DELEGATED HOUSEHOLDER DECISION

Item No.	Report of the Head of Development Management and Building Control	
Address:	95 POLE HILL ROAD HILLINGDON	
Development:	Single storey extension to the rear, first floor rear extension, conversion of roof space to habitable use to include 4x side dormers, 2 x rooflights and 2 new gable end windows.	
LBH Ref Nos:	282/APP/2025/1939	
Drawing Nos:	AR-PL-3000 AR-PL-3001 AR-PL-4001 AR-PL-4002 AR-PL-3002	
Date Plans received:	21-07-25	Date(s) of Amendments(s):
Date Application valid	21-07-25

Proposed Elevations

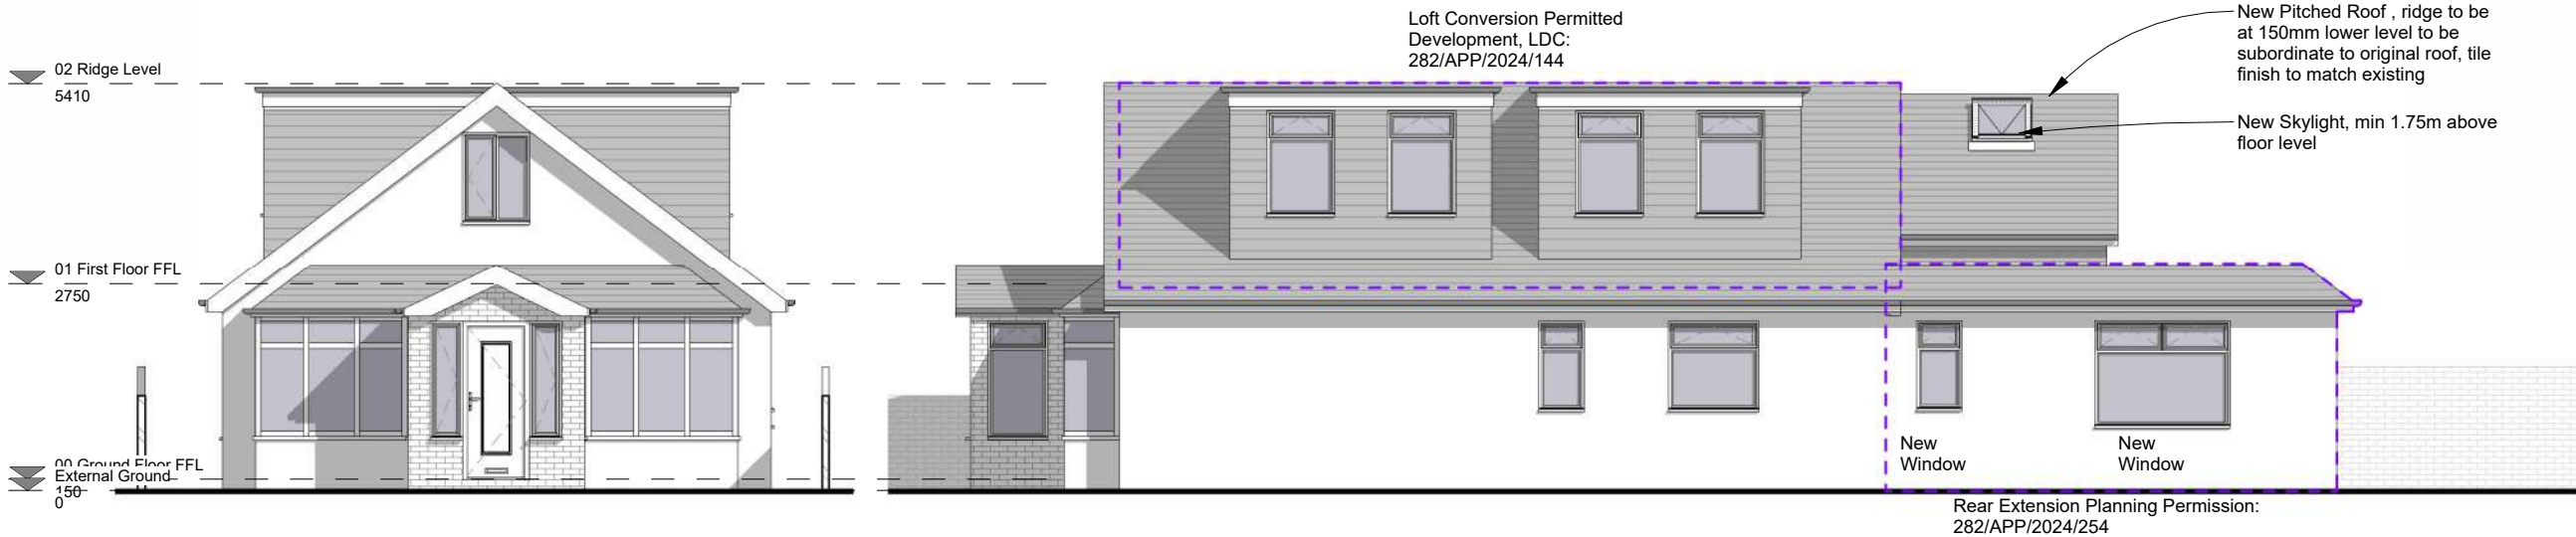
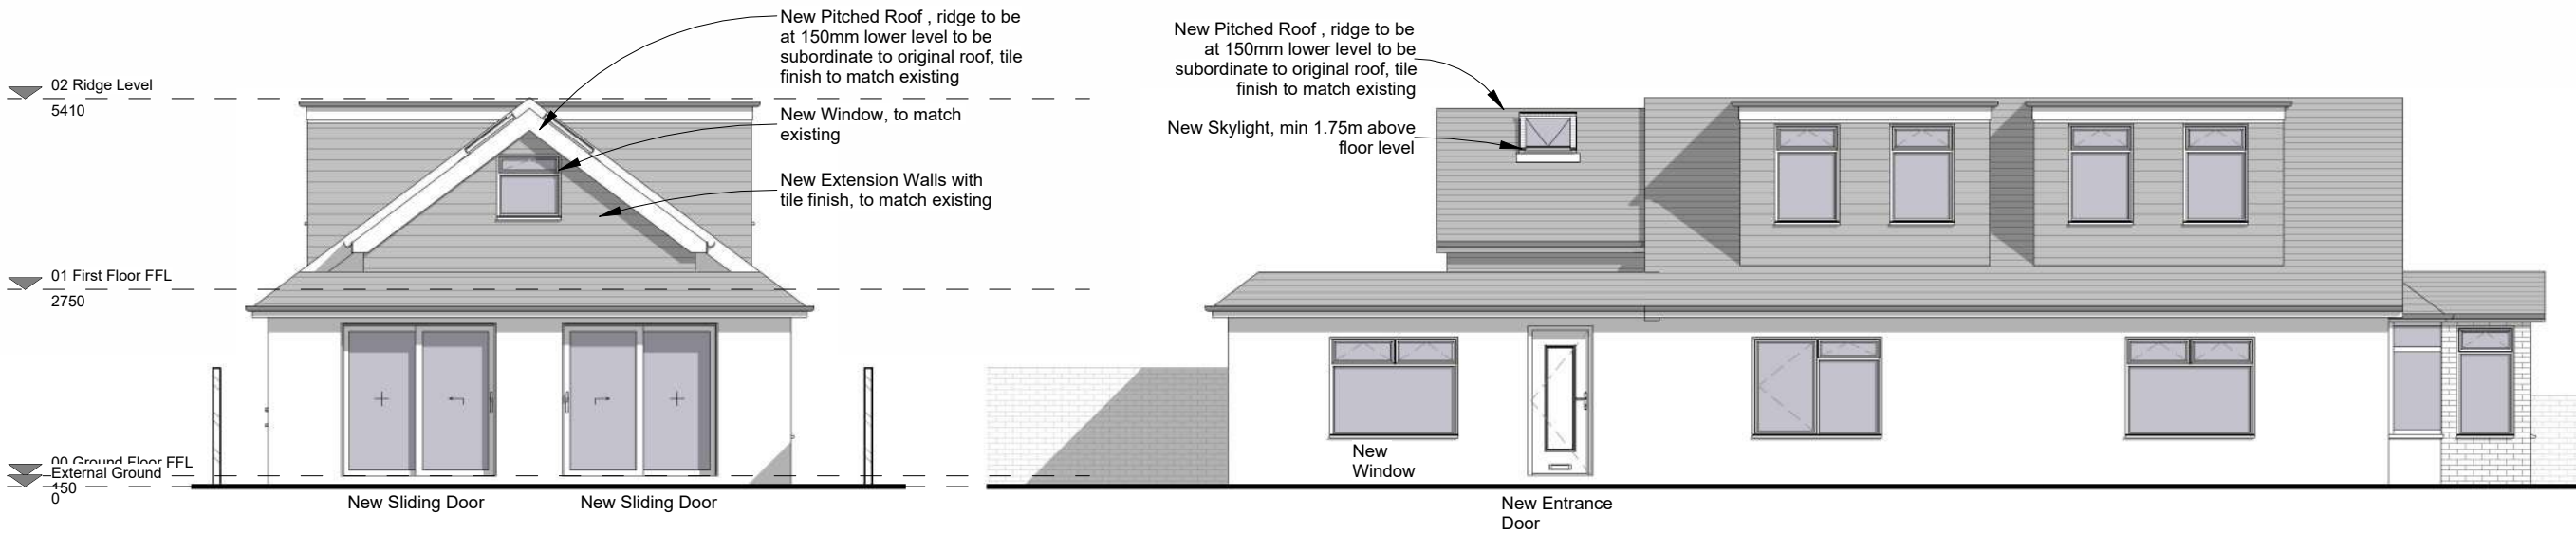
Significant concerns are however raised in terms of the quality of the accommodation provided to the future occupants of the property and in particular to the rear first floor bedroom. Under the approved certificate, the occupants of this property would have enjoyed a rear outlook. However the proposed first floor extension to accommodate the staircase proposed would remove this source of light and outlook. The occupants of this bedroom would be served by side facing windows within the dormer which would be obscure glazed and fixed shut. As such, the proposed development fails to provide an adequate level of outlook for the future occupiers of the rear first floor bedroom due to its reliance solely on side facing windows, which are fixed shut below 1.8m above FFL and obscure glazed. The proposal would therefore give rise to a substandard form of living accommodation to the detriment of the amenities of future occupiers contrary to Policy DMHB 11 and DMHD1 of the Hillingdon Local Plan: Part Two - Development Management Policies and Policy D6 of the London Plan (2021).

The proposed development fails to provide an adequate level of outlook for the future occupiers of the rear first floor bedroom due to its reliance solely on side facing windows, which are fixed shut below 1.8m above FFL and obscure glazed. The proposal would therefore give rise to a substandard form of living accommodation to the detriment of the amenities of future occupiers contrary to Policy DMHB 11 and DMHD1 of the Hillingdon Local Plan: Part Two - Development Management Policies and Policy D6 of the London Plan (2021)
